RE: 6/2019/0857/MAJ – Stanborough Park, North Stanborough Park, Stanborough Road, AL8 6DF

Having reviewed the Flood Risk Review prepared by Conisbee, reference 171116/T Gavaza, version 1.4, dated 1st April 2019 and additional information submitted to the LPA, we can confirm that we, Hertfordshire County Council as the Lead Local Flood Authority are now in a position to remove our objection on flood risk grounds.

Hertfordshire County Council

Drawing Status
PRELIMINARY
Project
**STANBOROUGH PARK
SPLASHLANDS**
Title
CATCHMENT PLAN
Drawing No
171116-CON-X-00-DR-C-1010

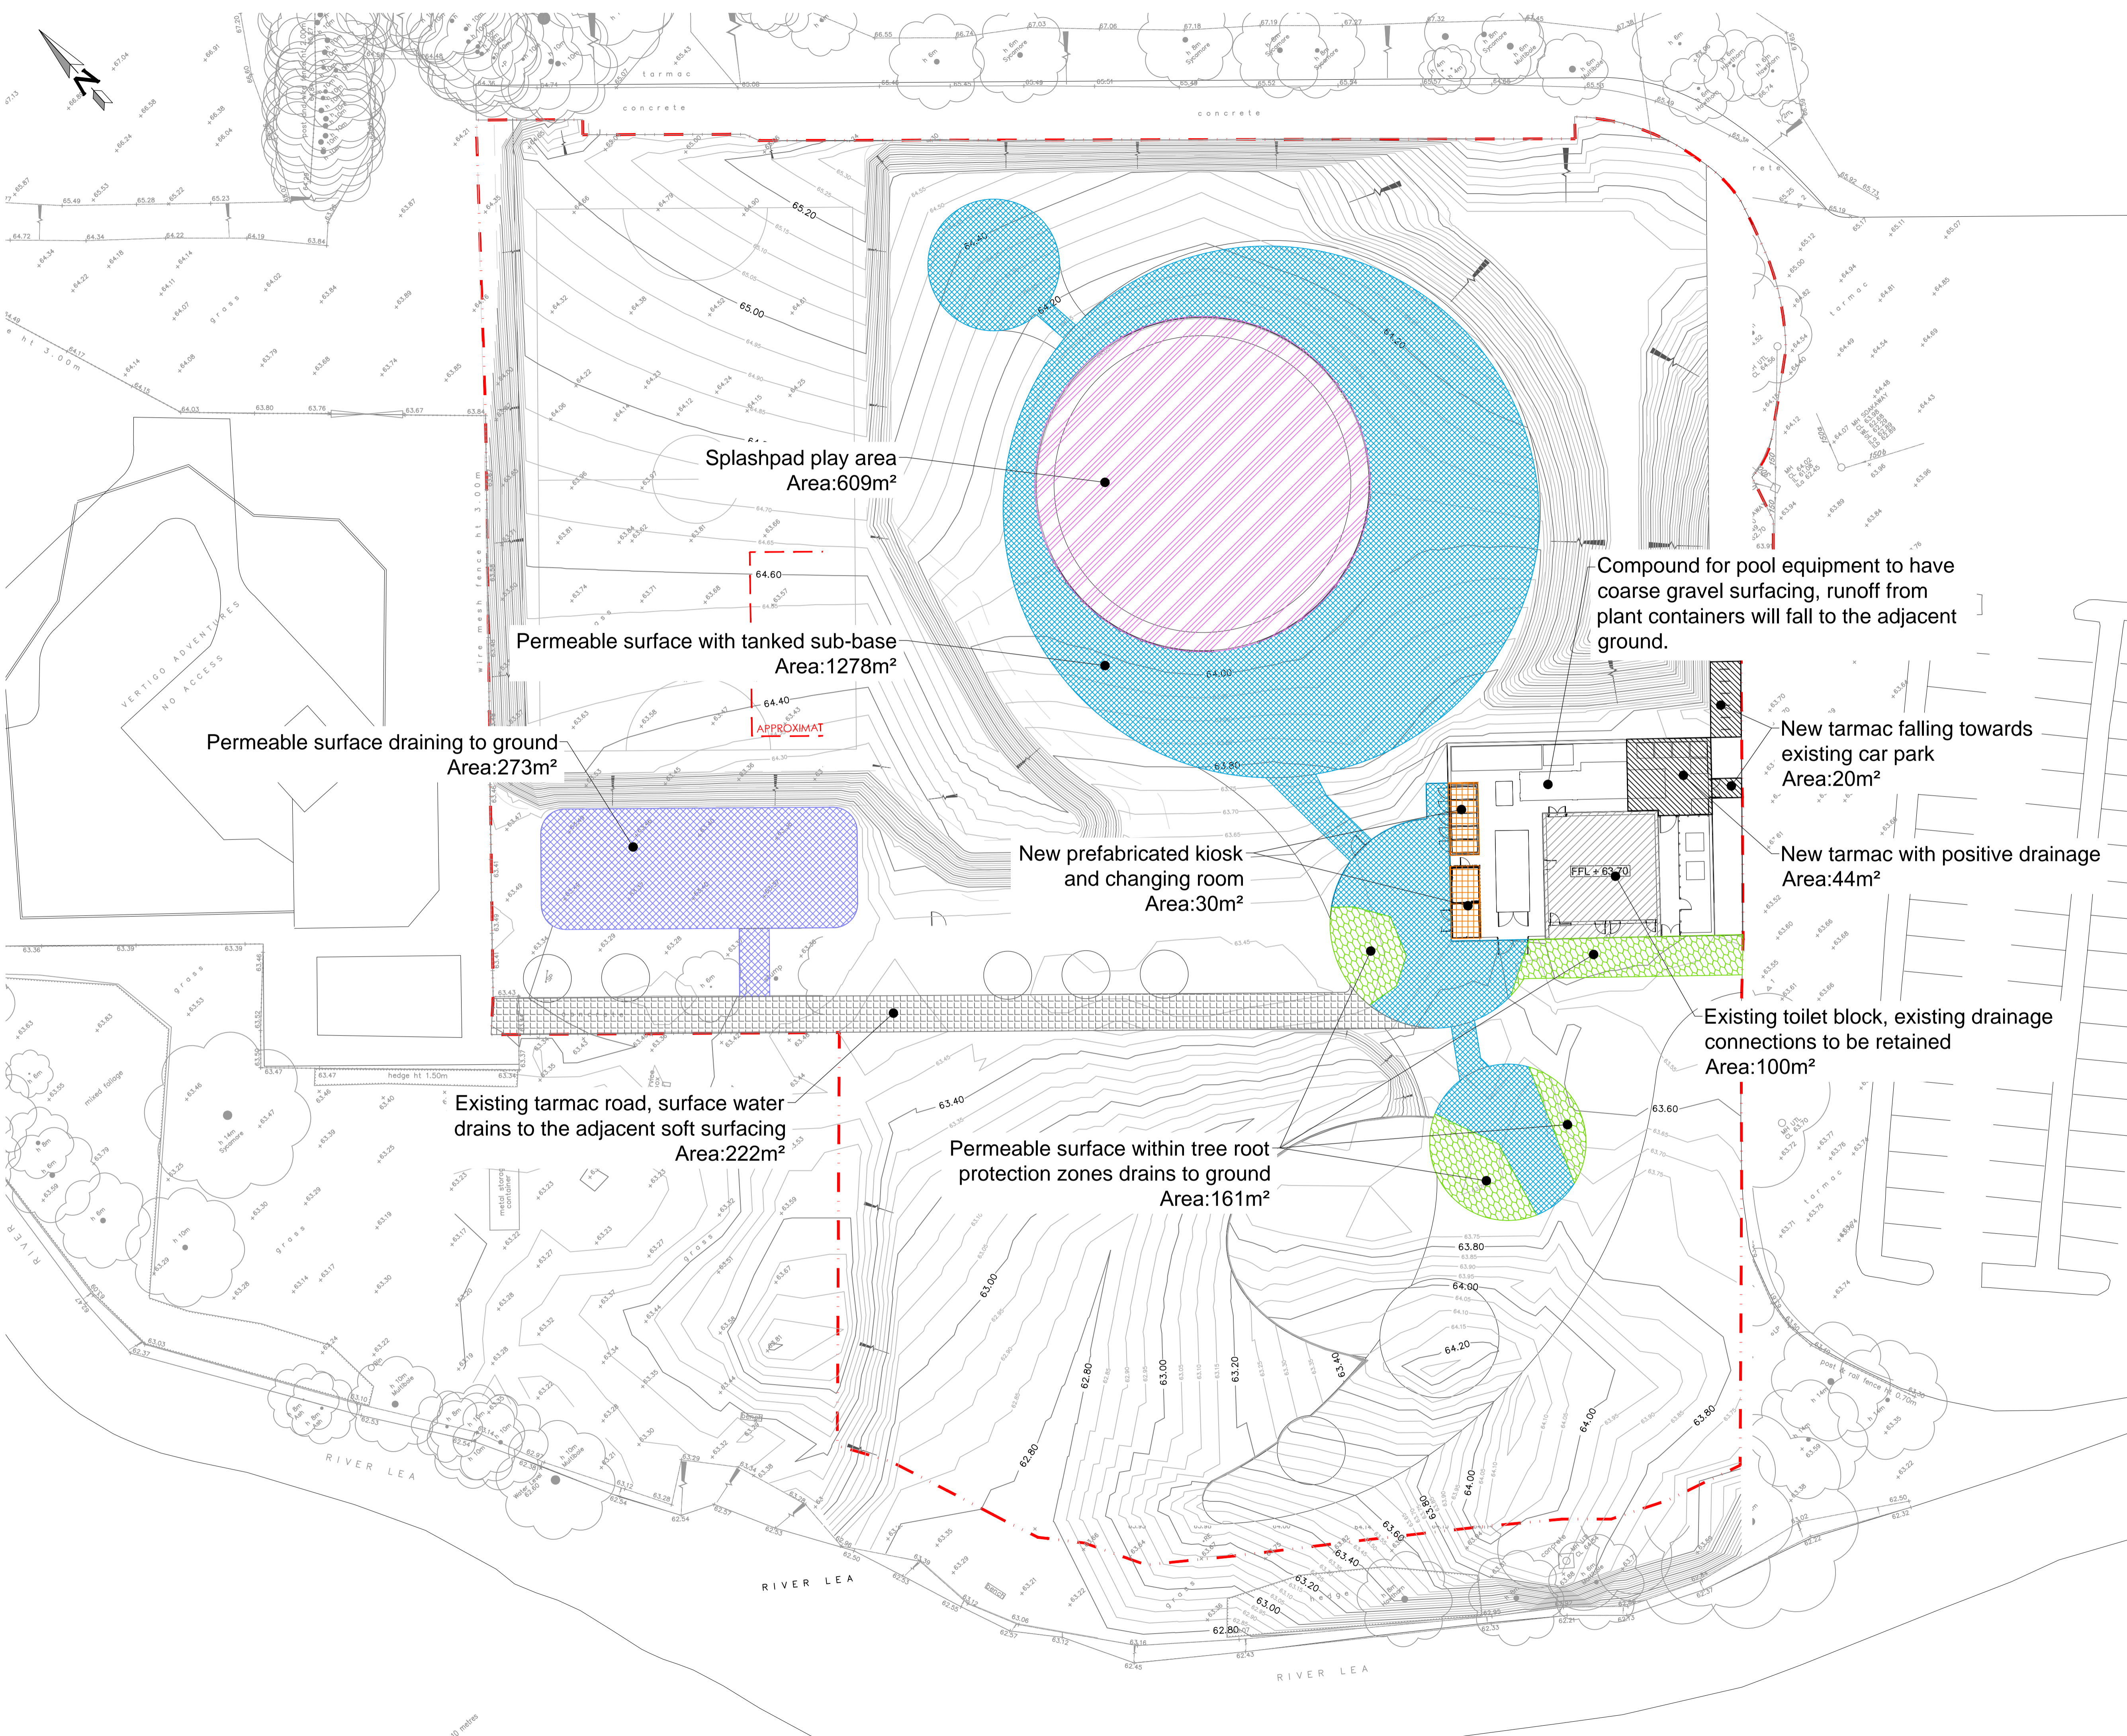
The drainage strategy is based upon permeable paving features, permeable paving with sub-base storage, two permavoid tanks storage and discharge into a main river through a swale structure. We note surface water calculations have been provided and ensure that the drainage strategy caters for all rainfall events up to and including 1 in 100 plus 40% for climate change with 2 l/s discharge to the River Lea.

The development permitted by this planning permission shall be carried out in accordance with the approved surface water drainage assessment carried out by Conisbee, drawing number 171116-CON-X-00-DR-C-1000, titled Drainage Strategy, revision T3, dated 20 May 2019 and the following mitigation measures detailed within the FRA:

1. Limiting the surface water run-off generated by the critical storm events so that it will not exceed the surface water run-off rate of 2 l/s during the 1 in 100 year event plus 40% of climate change event.
2. Providing storage to ensure no increase in surface water run-off volumes for all rainfall events up to and including the 1 in 100 year + climate change event providing a minimum of 172 m³ (or such storage volume agreed with the LLFA) of total storage volume in permeable paving with sub-base features and permavoid tanks.
3. Discharge of surface water from the private drainage on site into the River Lea.

Prior occupation of the development, a detailed surface water drainage scheme for the site based on the approved drainage strategy and sustainable drainage principles should be submitted to and approved in writing by the local planning authority. The scheme shall include:

1. Final, detailed, as-built drainage layout including the location and provided volume of storage of all SuDS features, pipe runs and discharge points.
2. Detailed drawings of all SuDS features included within the drainage strategy.
